TO: planning@cherwell-dc.gov.uk

25th July 2019

RESPONSE TO PLANNING APPLICATION 19/01177/F
Erection of ten residential dwellings off South Side, Steeple Aston

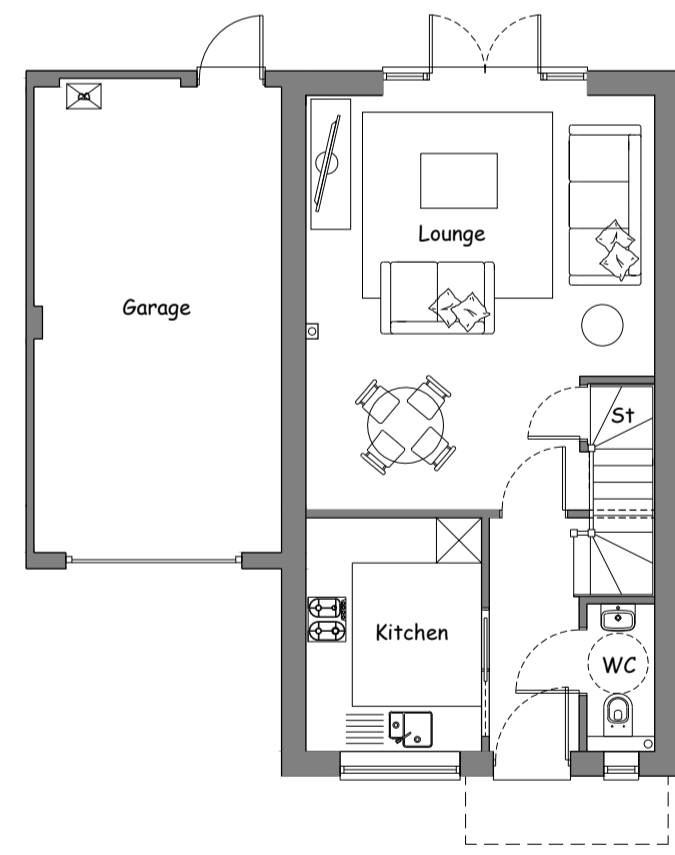
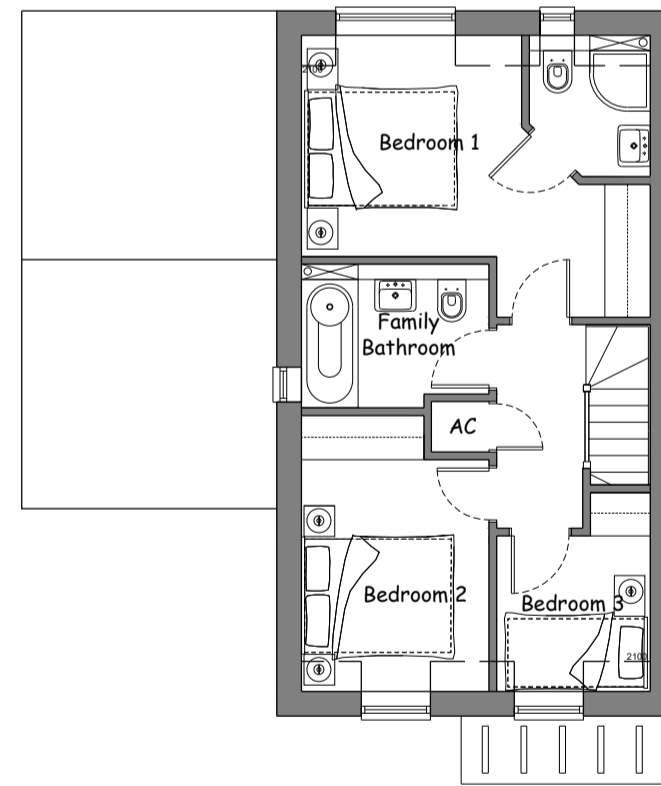
- the close proximity of the 3-bed dwelling on plot 1 to the industrial use adjacent, being a car maintenance workshop, with planning approval for a large extension.

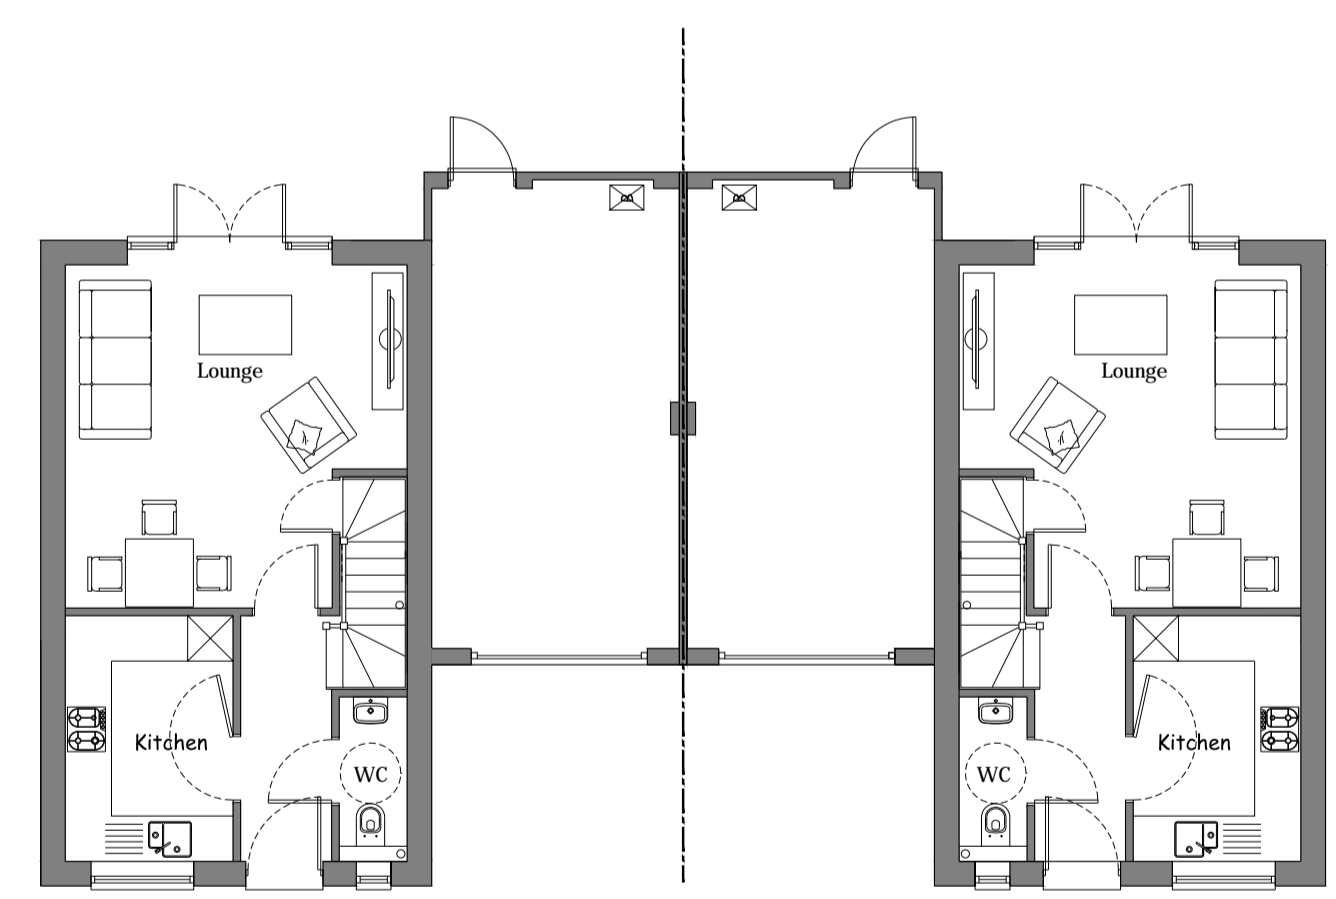
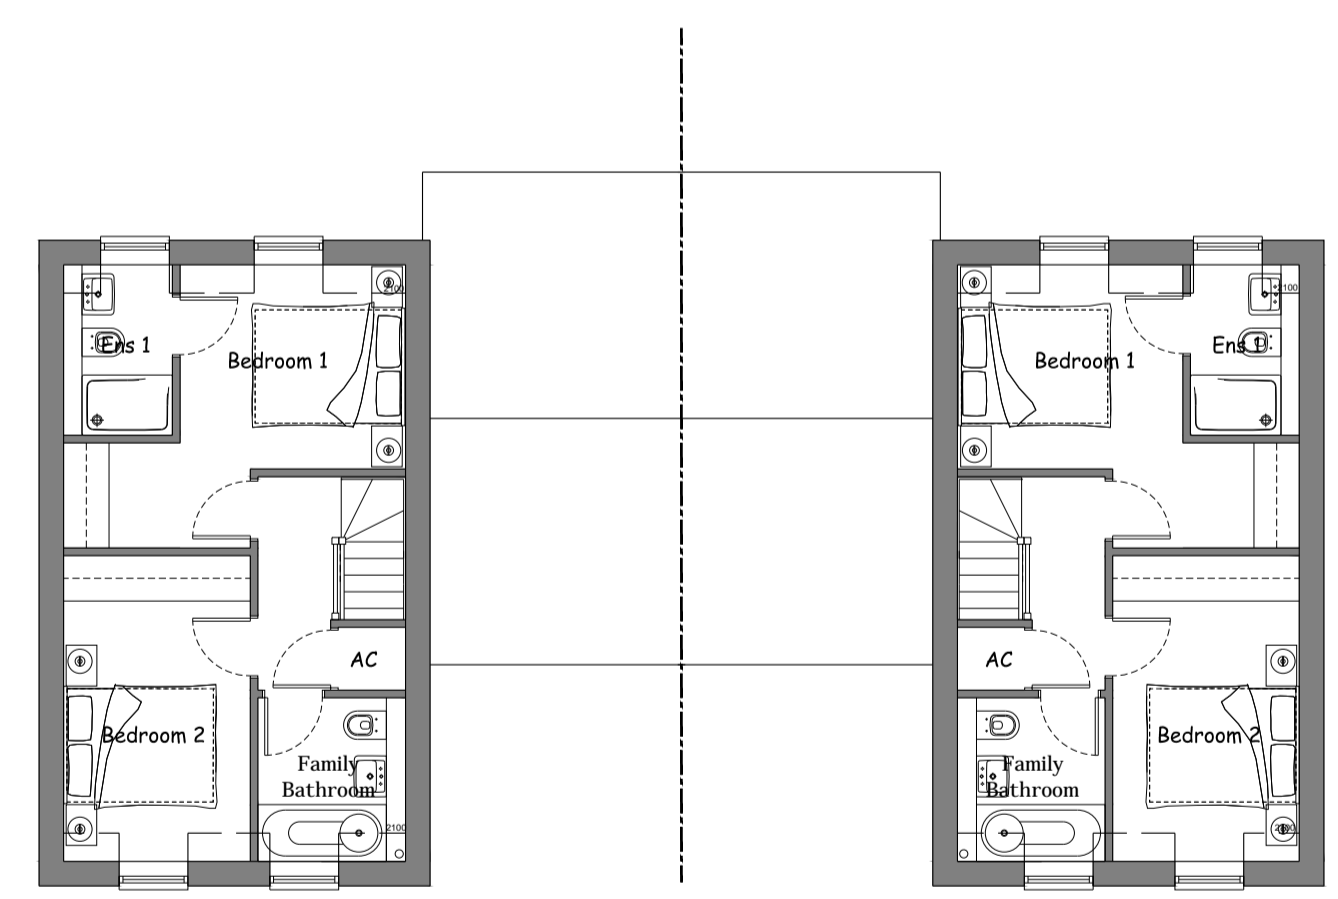
- the separation of the semi-detached pair of 2-bedroom dwellings (in an earlier scheme) into two dwellings attached by their garages has resulted in elevations of unacceptable proportions, a form alien to the village, and usually only found in some modern housing estates where design quality is largely absent (see images below). This error, which applies also to the adjacent 3-bed house, does not support the applicants’ view that the scheme is “of the highest architectural quality”, nor does it meet the similar requirements of policy PD5.

- the design uses a number of building forms that are not represented in the village. For example, the use of hipped roofs on the garages (see image below).
